Application Ref:	3/2025/0507			 <p>Ribble Valley Borough Council www.ribblevalley.gov.uk</p>
Date Inspected:	22/07/2025	Site Notice:	22/07/2025	
Officer:	MC			
DELEGATED ITEM FILE REPORT:				APPROVAL

Development Description:	Application for Planning Permission for conversion of barn to create new dwelling. Demolition of existing farm block.
Site Address/Location:	Lower Reaps Farm, Whinney Lane, Mellor BB2 7EL

south elevation

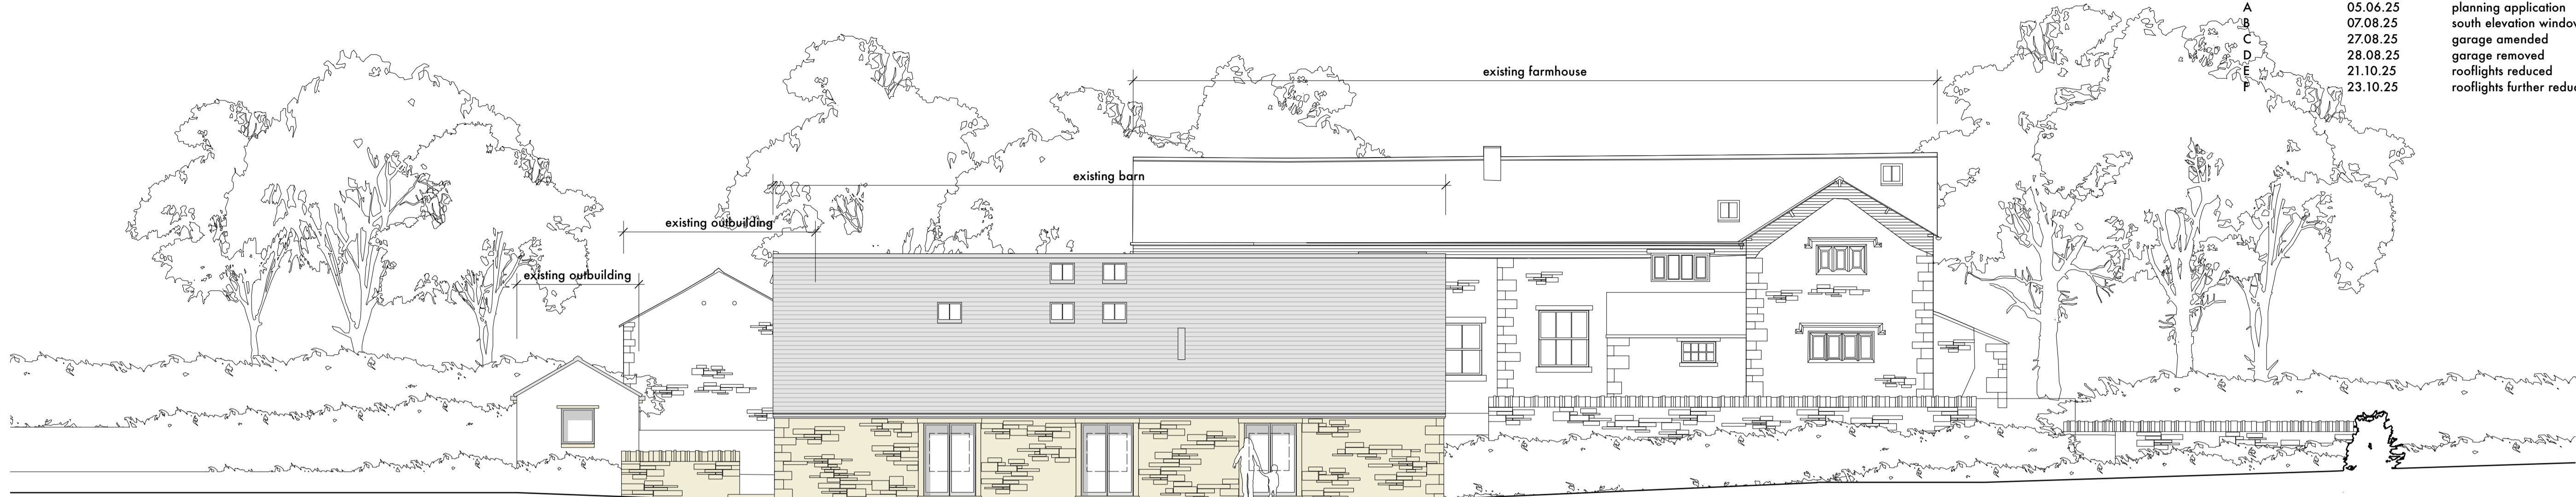
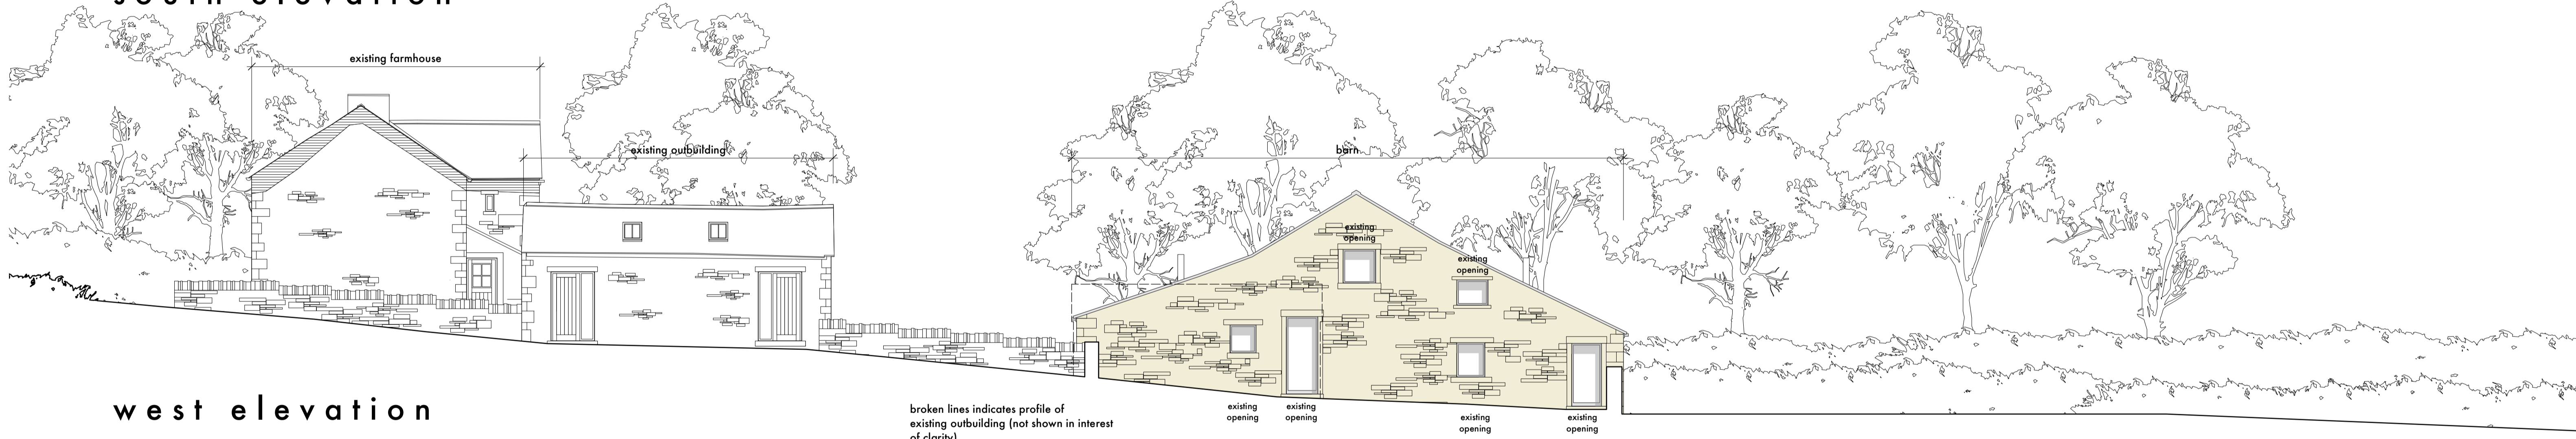
The western elevation would re-use existing openings to provide doors and windows. To the south elevation, 3 no. existing openings would be enlarged to form double doors. The level of glazing has been reduced from as originally submitted and the Conservation and Heritage Officer considers that as this has been reduced to align with the current window openings, the harm is reduced.

- Remove detached garage from the scheme
- Reduce the width of openings to the south elevation
- Removed the parking areas associated with the listed farmhouse from the site plan as these do not relate to this application
- Removal of larger parking area to the west of the barn following comments received from LCC Footpath Officer.
- Alterations to rooflights
